From: Thomas Callaway
Sent: 21 March 2014 11:35
To: Planning.Responses
Subject: RE: Planning Consultation on AW/69/14/DOC

APPLICATION **AW/69/14/DOC**

Site Address: 9 Nuffield Close Bognor Regis PO21 5RA

Description of Works: Application for approval of details reserved by conditions 3 (schedule and samples of materials), 4 (screen fences), 6 (surface water drainage), 7 (retention of existing trees/hedges) and 9 (cycle storage) following a grant of planning permission AW/148/13/.

Plan 1B
Surface Water Drainage Scheme - Into
existing surface water public sewer system.
(Alternative Proposal)

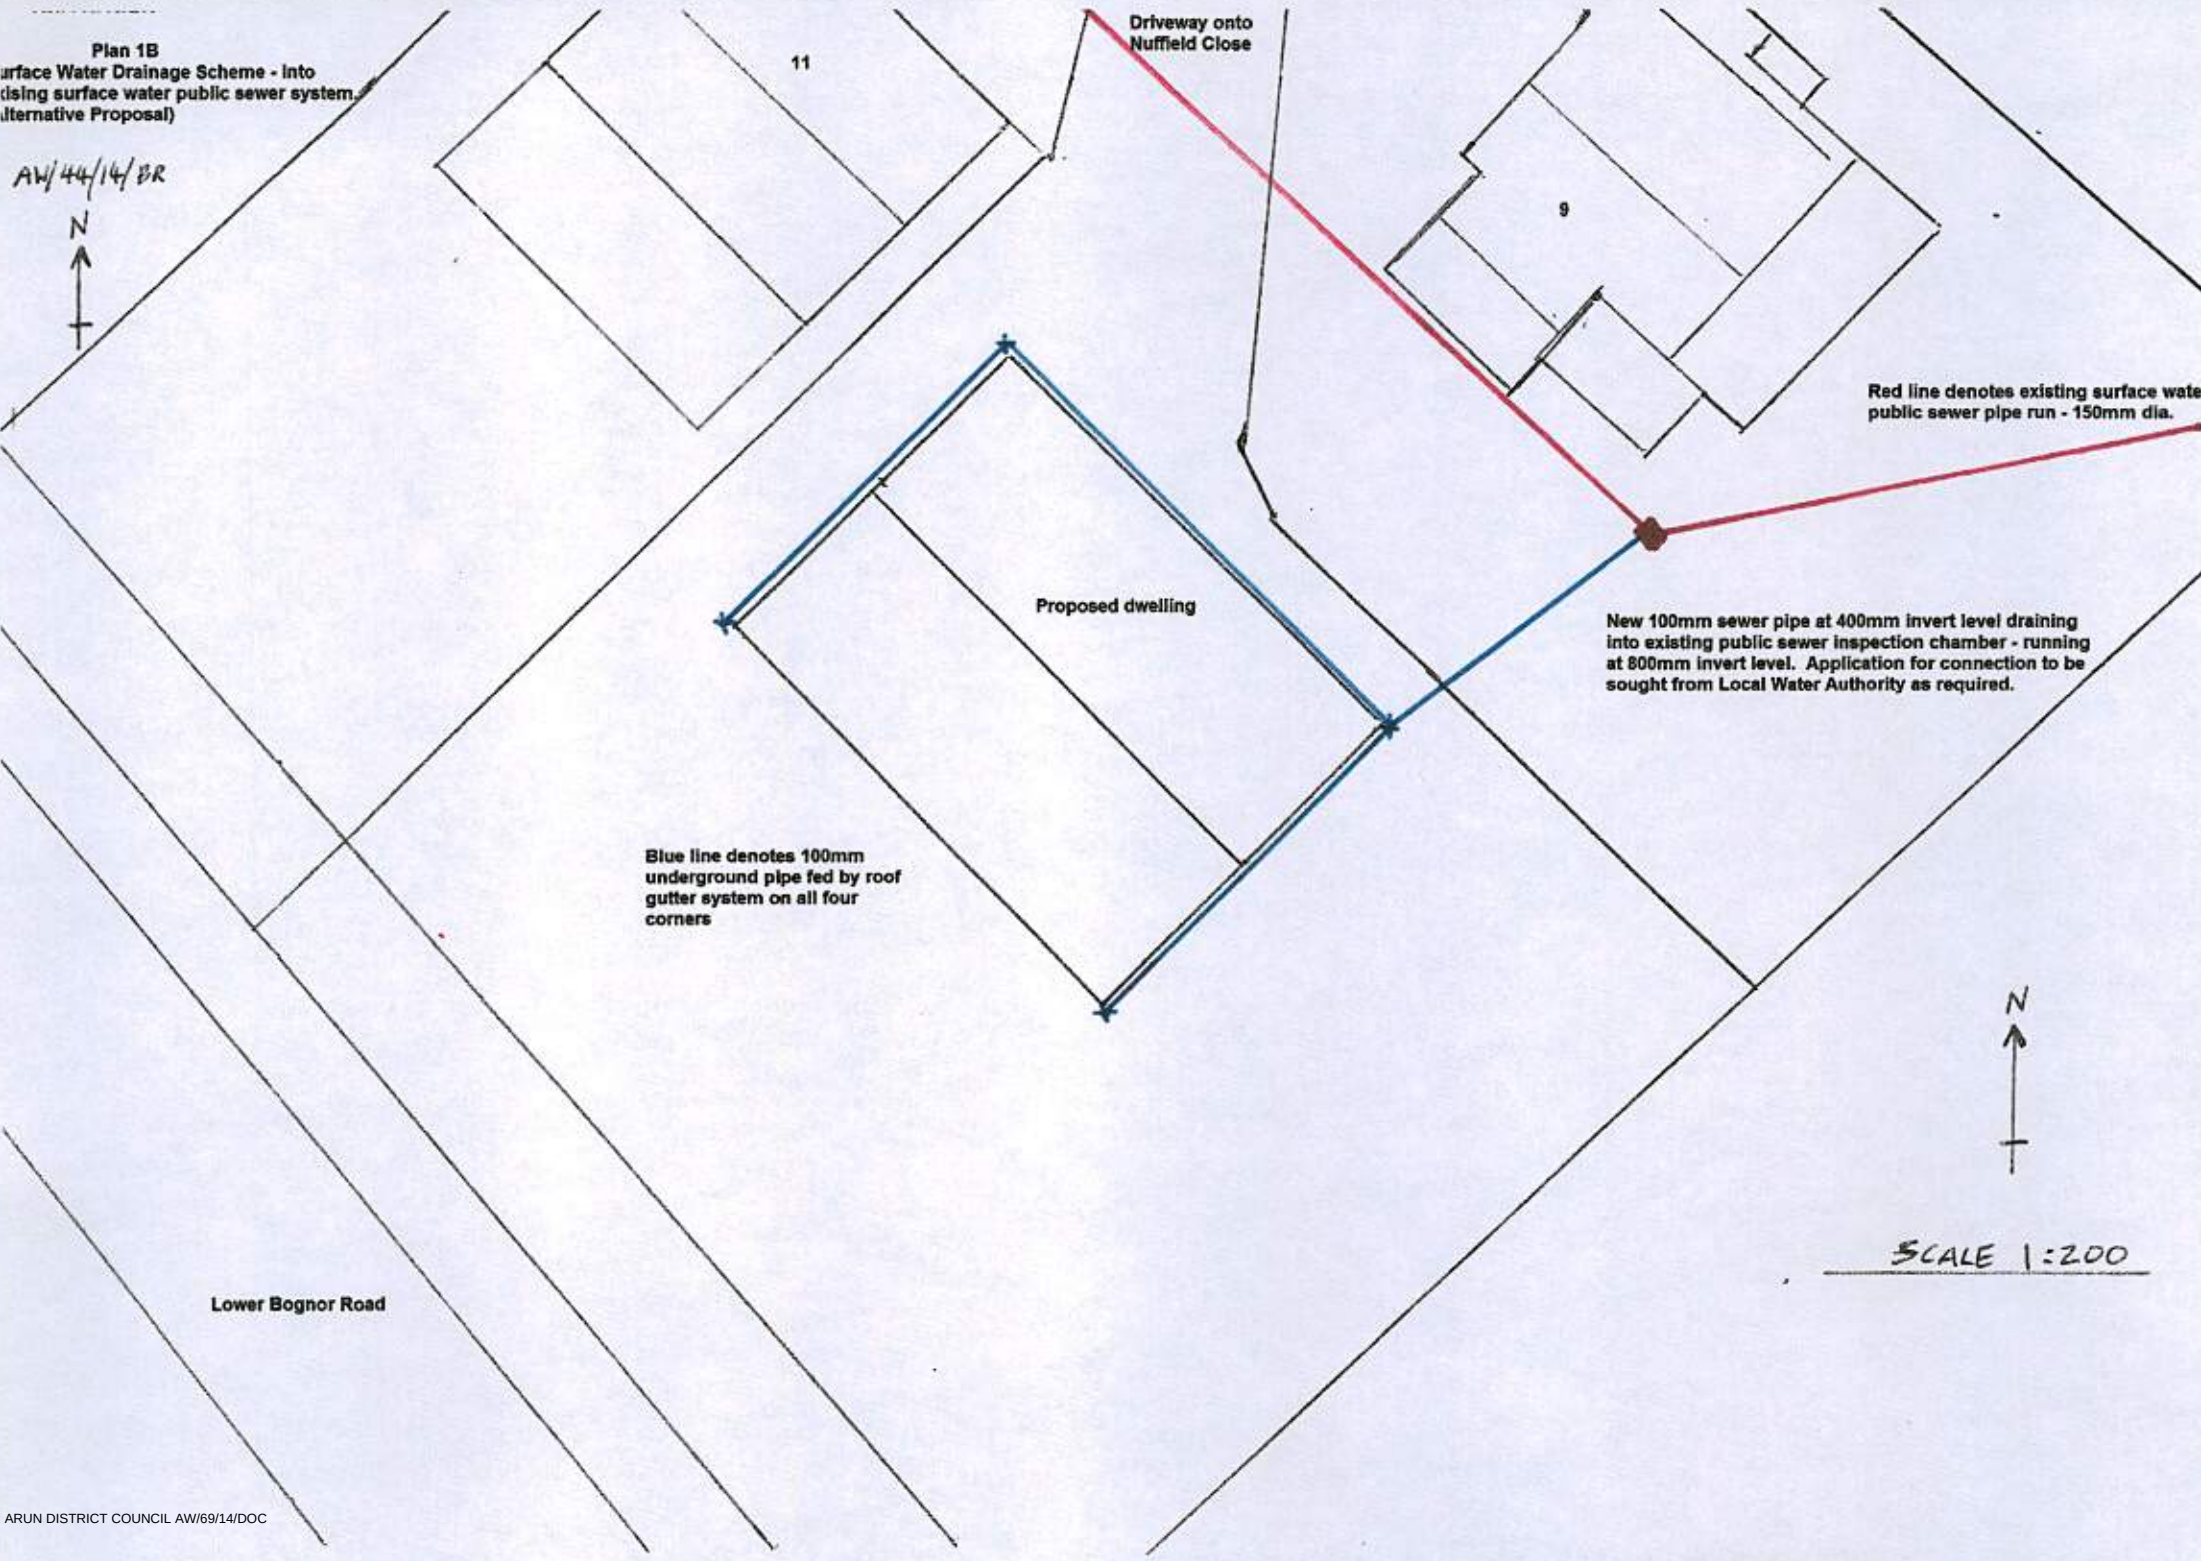
The proposal to drain surface water to soakaway should be prioritised over the proposal considering draining to the sewer. The groundwater monitoring and percolation testing results are noted.
